Consultation Response from: KC Environmental Health (Pollution & Noise Control)		
2021/94344 – Former North Bierley Waste Water Treatment Works, Oakenshaw, BD12 7ET		
Discharge condition 8 (Construction Environmental Management Plan) and 26 (Construction Surface Water Drainage) on (phase 4 of) previous permission 2016/92298 for outline application for re-development of former waste water treatment works following demolition of existing structures to provide employment uses (use classes B1(c), B2 and B8)		
Date Responded: 8 th February 2022	Responding Officer: Natalie Heaney	Responding Ref: WK/202141296
Condition 26 is outside the remit of Environmental Health. Condition 8 - Construction Environment Management Plan To discharge Condition 8, a Construction Environment Management Plan by GMI Construction Group, dated 2nd November 2021 (ref: Rev 4) has been submitted. Our comments relate to those within the remit of Environmental Health, these are, working hours, noise and vibration from construction activities and vehicle movements, dust from construction activities and vehicle movements and artificial lighting used in connection with all construction-related activities and site secur

Figure 1 – Site Location and Site Plan

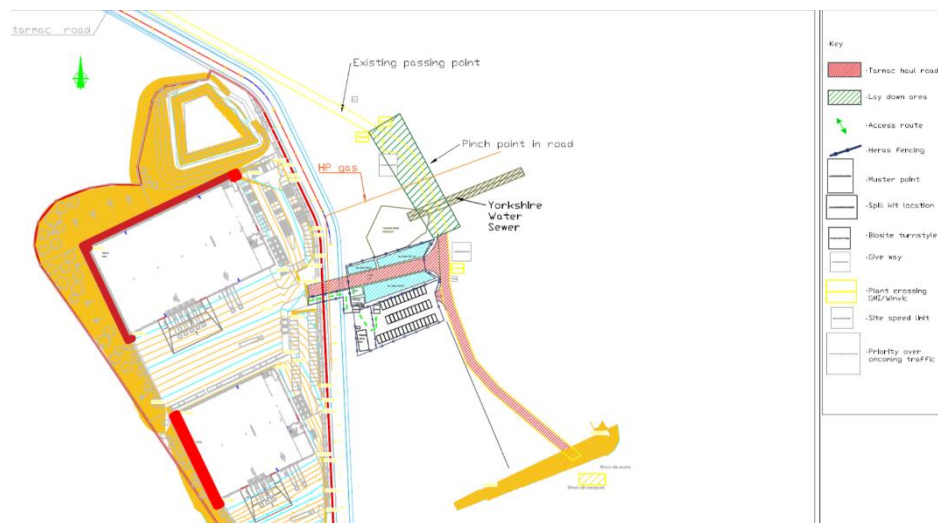
4. No site plan has been provided showing the location of any control measures or the location of welfare facilities, lighting, compounds etc. These should be included in the construction management plan.
